Norfolk Boreas Offshore Wind Farm

Appendix 19.1

Norfolk Vanguard Ground Conditions and Contamination Consultation Responses

Applicant: Norfolk Boreas Limited
Document Reference: 6.3.19.1
RHDHV Reference: PB5640-006-1901
Pursuant to APFP Regulation: 5(2)(a)

**Royal HaskoningDHV**  
Enhancing Society Together

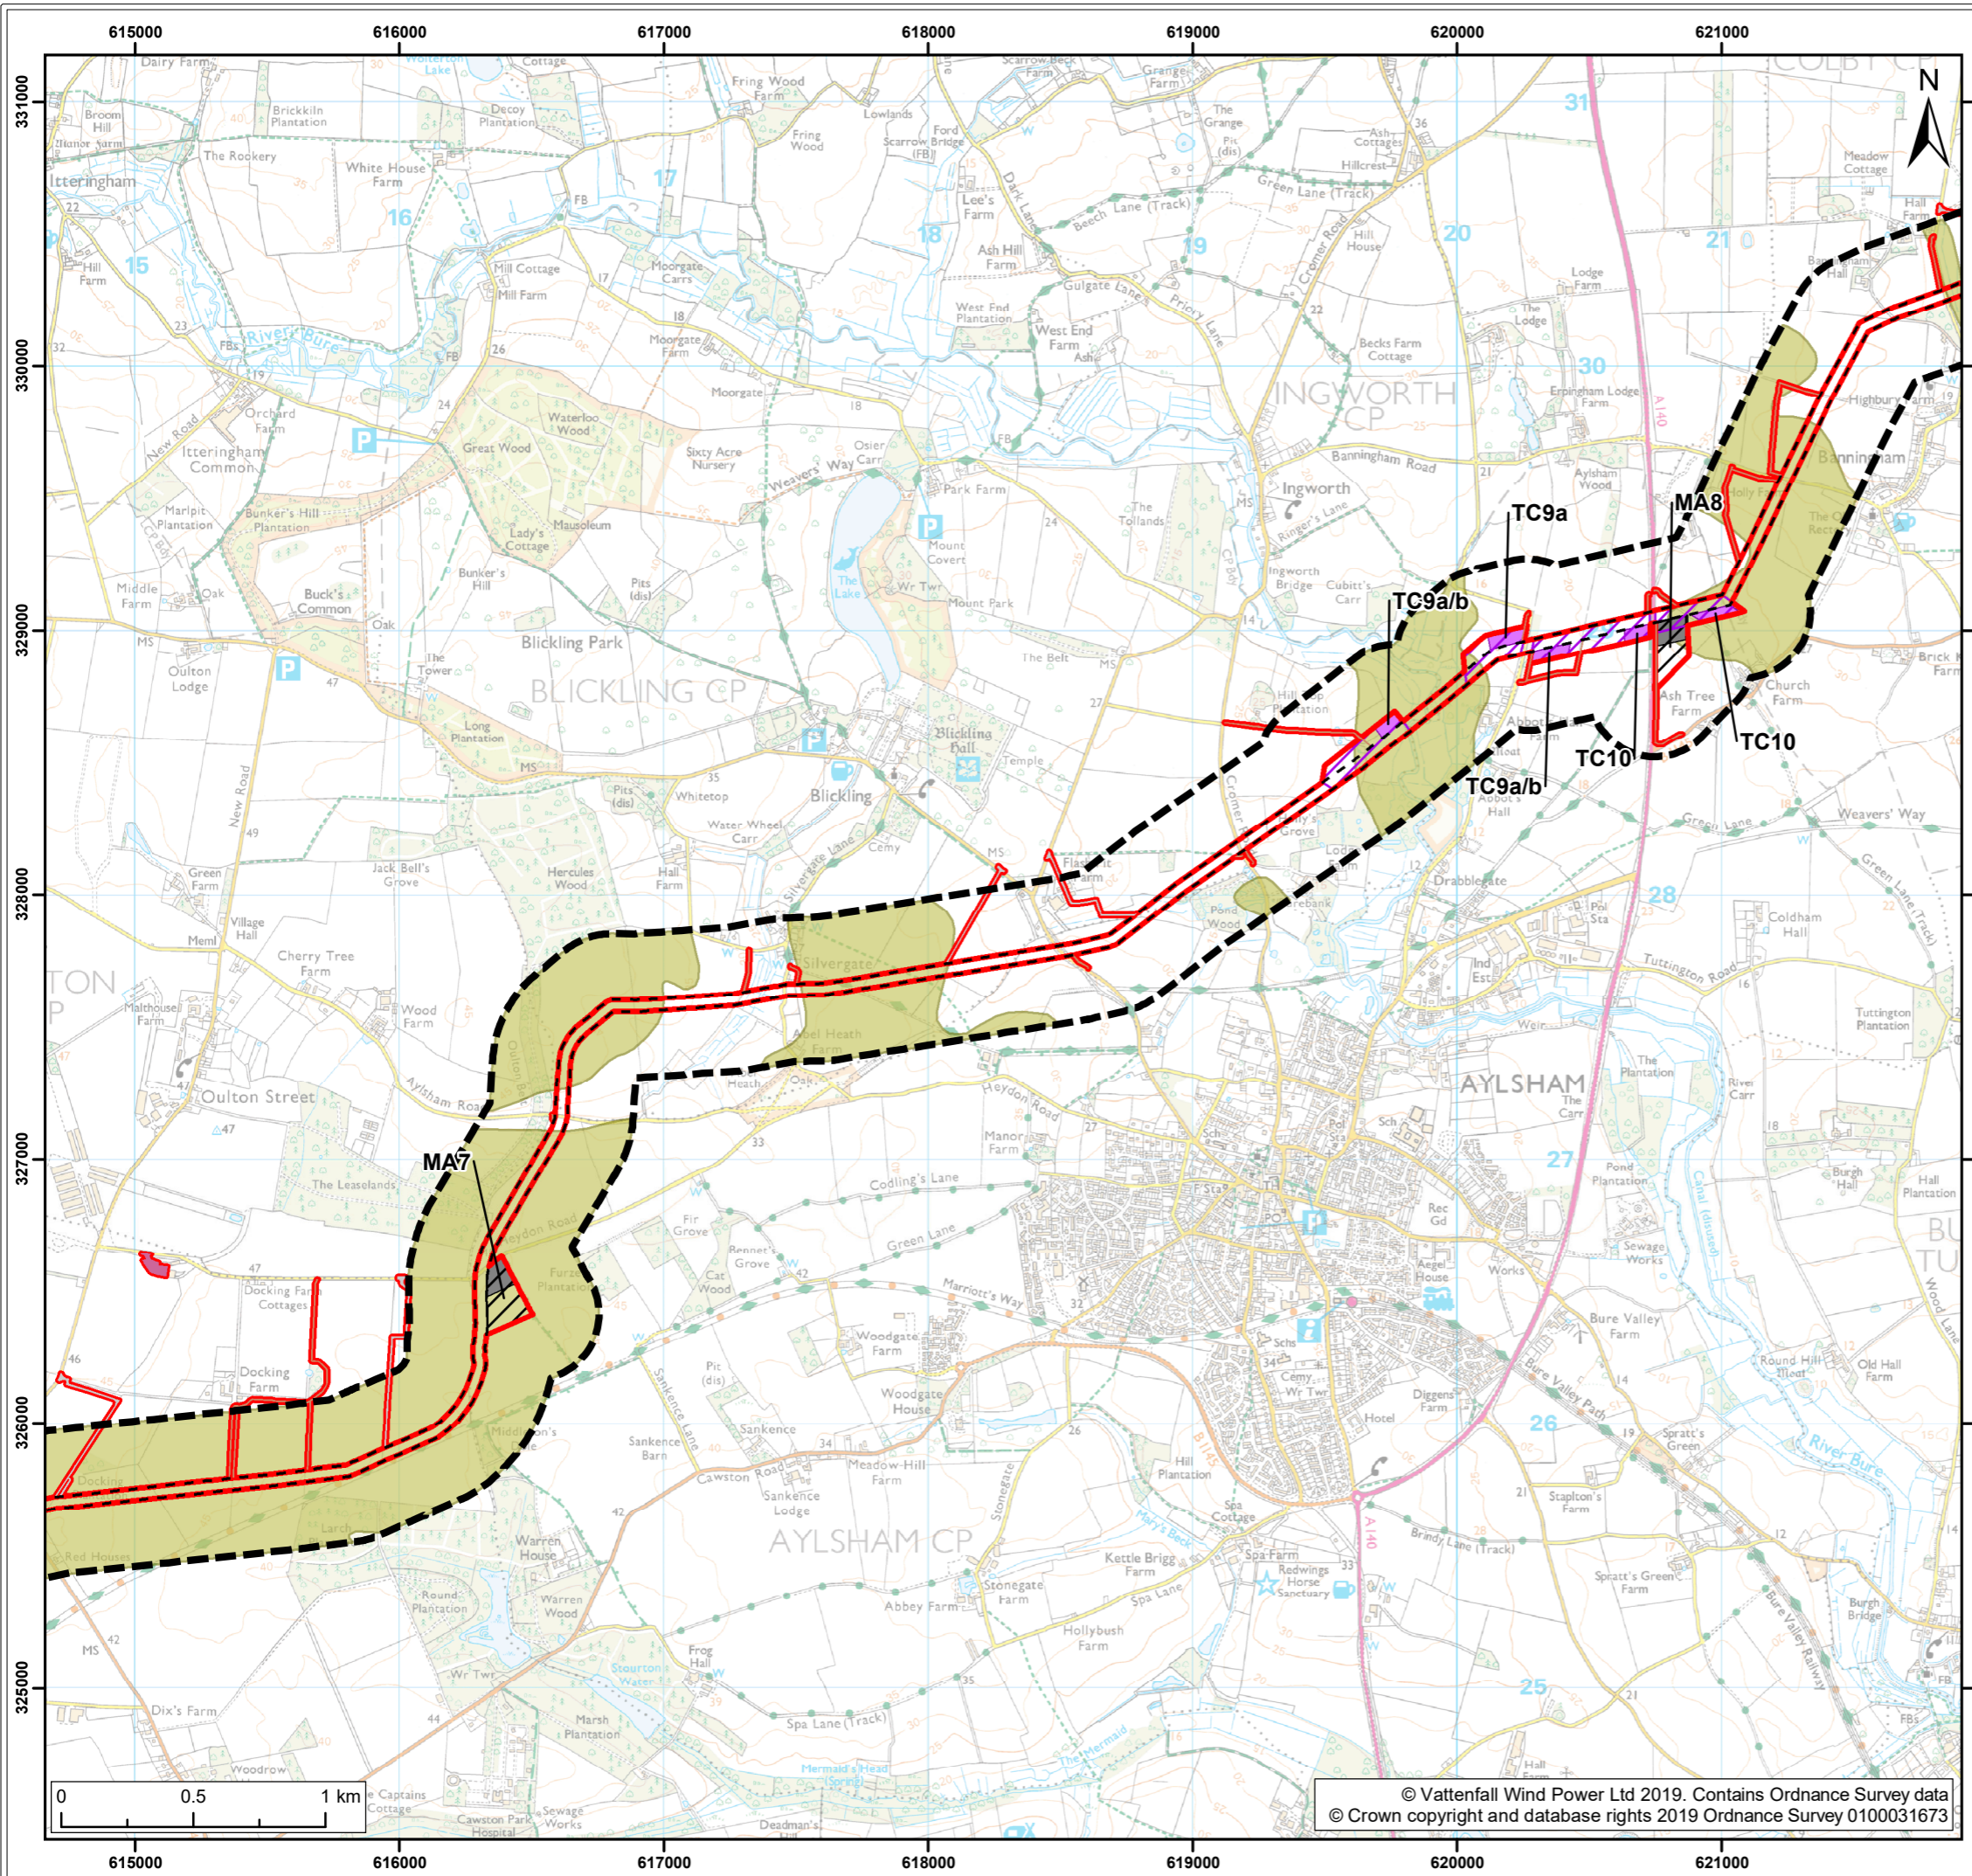
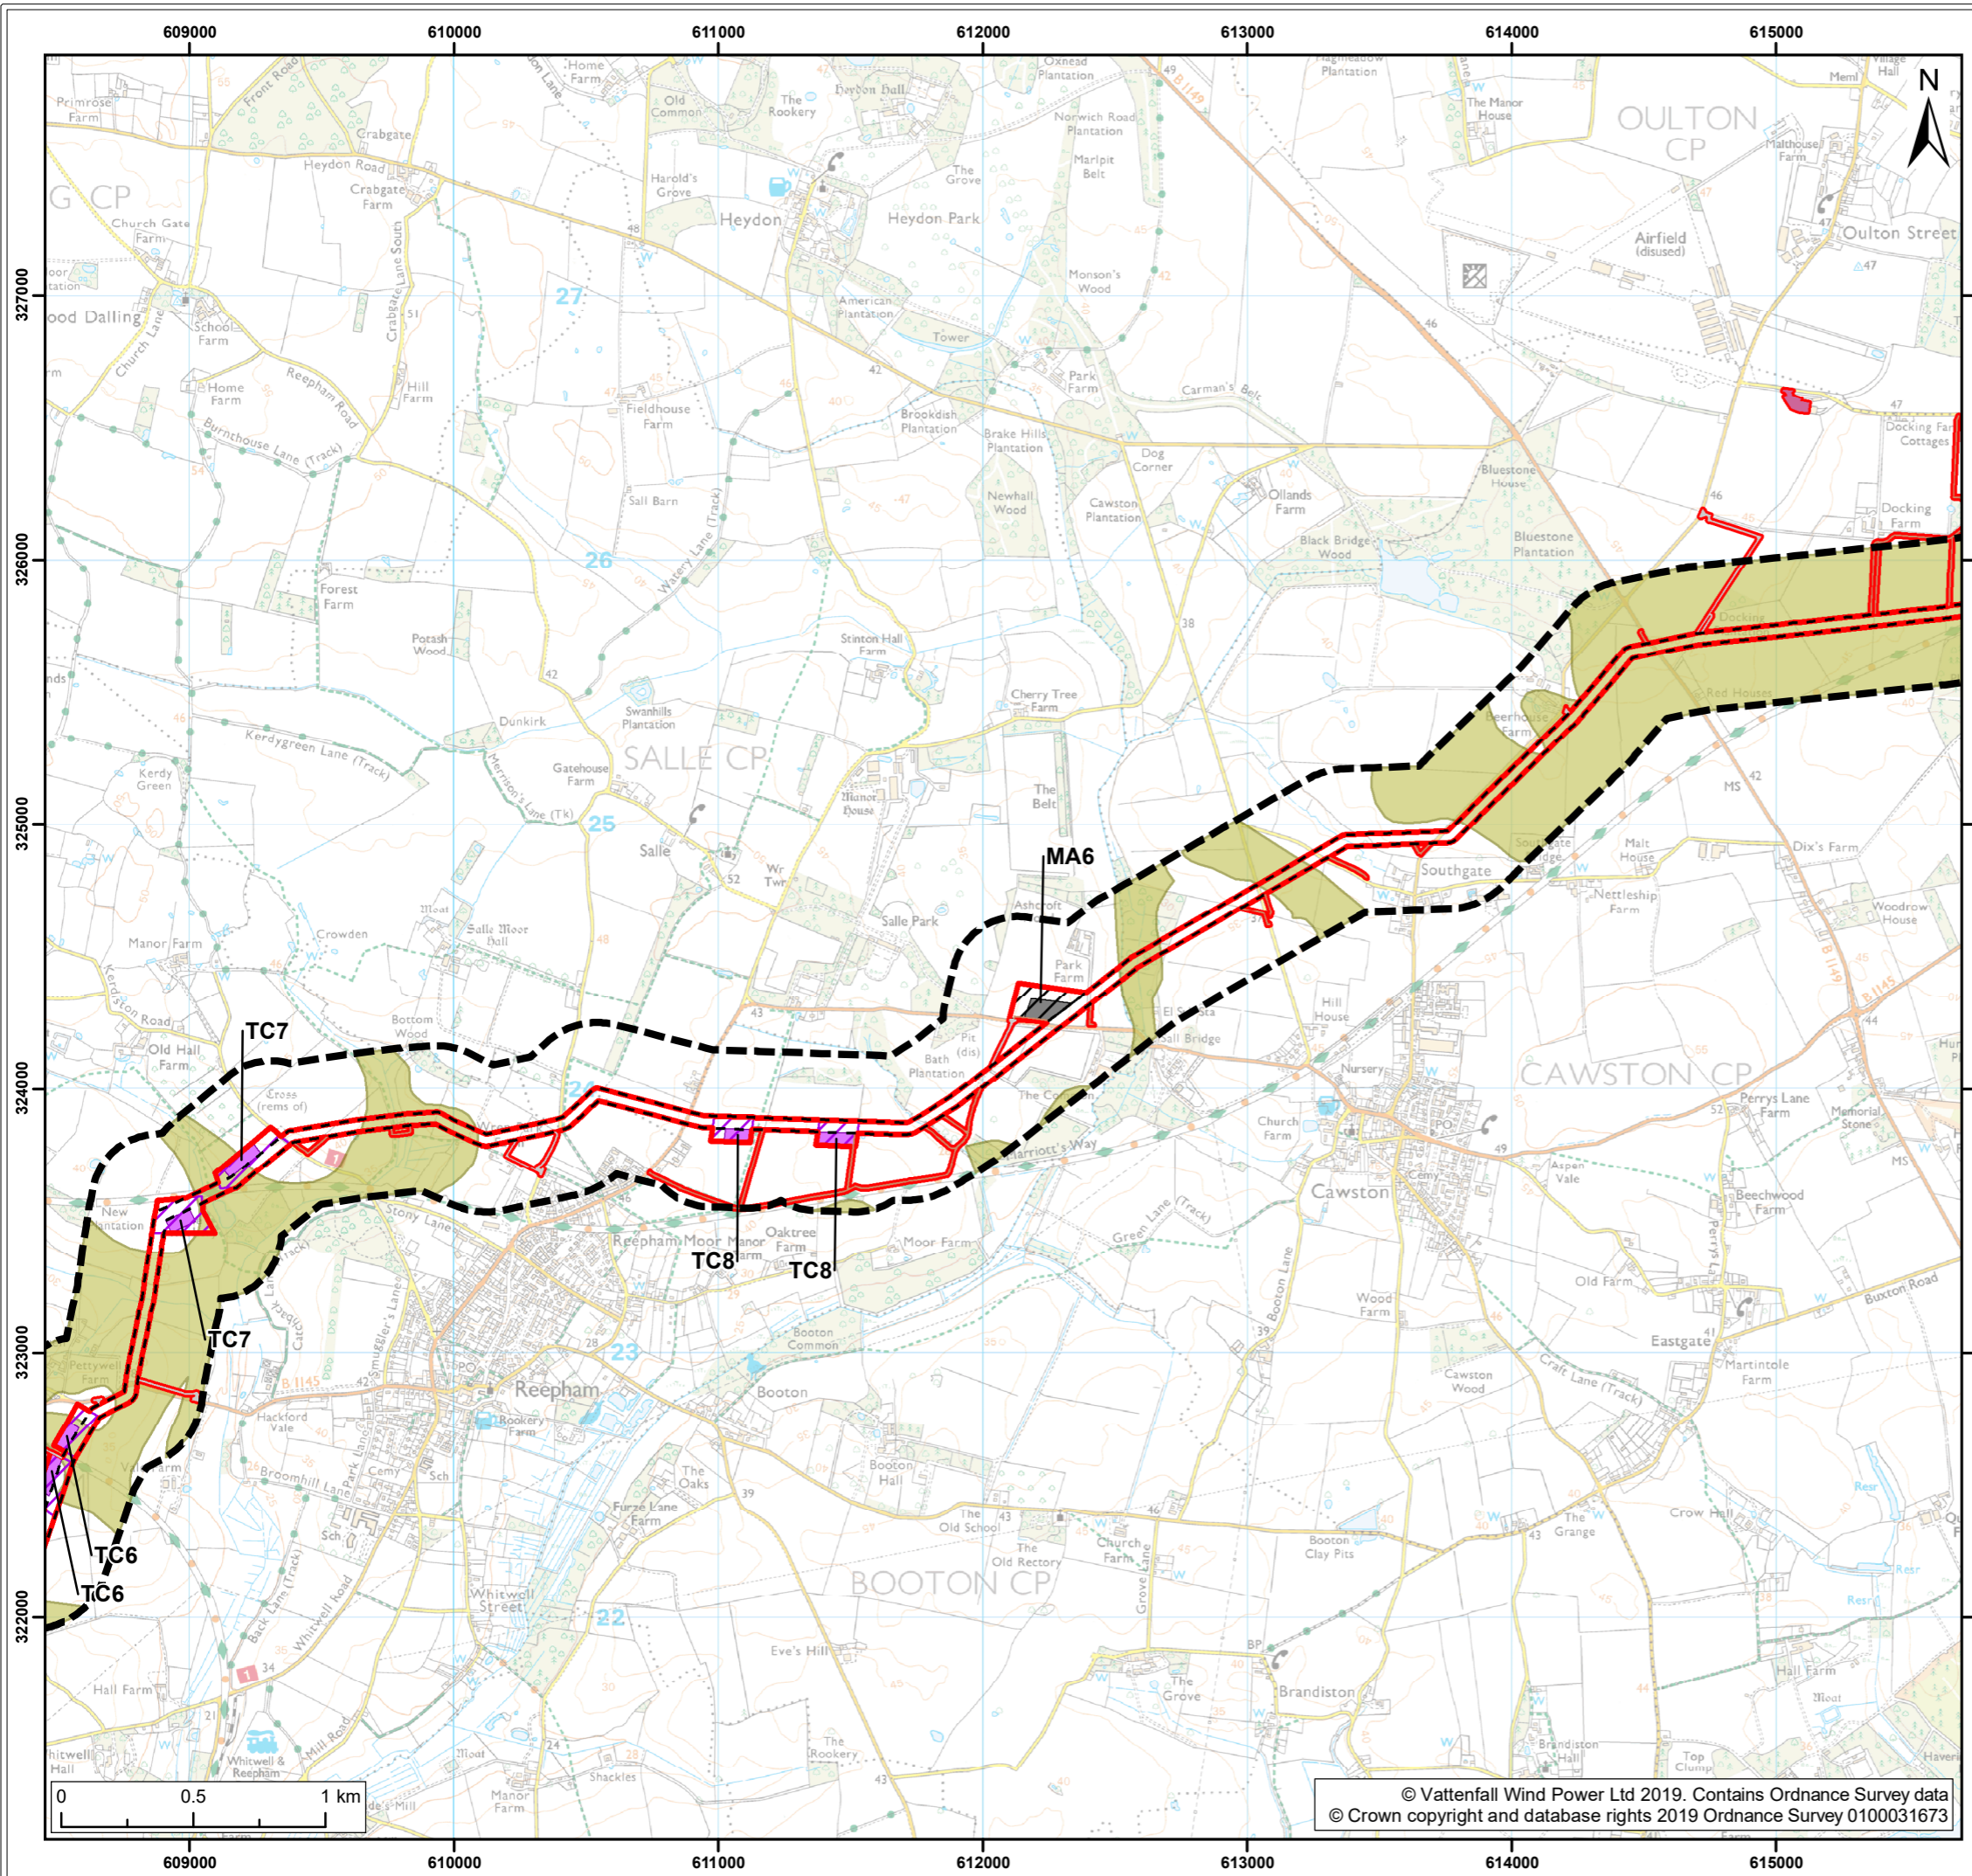
Consultee	Date /Document	Comment	Response / where addressed in the Norfolk Boreas ES Chapter 19
Secretary of State (SoS)	11 th November 2016 Scoping Opinion	The ES [Environmental Statement] should identify and assess potential impacts on the Mineral Safeguarding Areas underlying the onshore scoping area (see the comments of Norfolk County in Appendix 3 of this Opinion).	Mineral safeguarding data has been shared by Norfolk County Council and is considered within the assessment in sections 19.2 and 19.7.4.7.
SoS	11 th November 2016 Scoping Opinion	Paragraph 304 of the Scoping Report notes there is rapid cliff erosion on the coast of north east Norfolk. The potential impacts of landfall works on coastal processes, including erosion and deposition, should be addressed with appropriate cross reference to other technical reports including landscape and visual impacts. Reference should be made to the Kelling to Lowestoft Ness Shoreline Management Plan, where appropriate.	Rapid cliff erosion on the coast of north east Norfolk is considered within the assessment in sections 19.6 and 19.7.4.1. Appendix 4.5 Coastal Erosion Study of Chapter 4 Site Selection and Assessment of Alternatives also provides information in relation to coastal erosion.
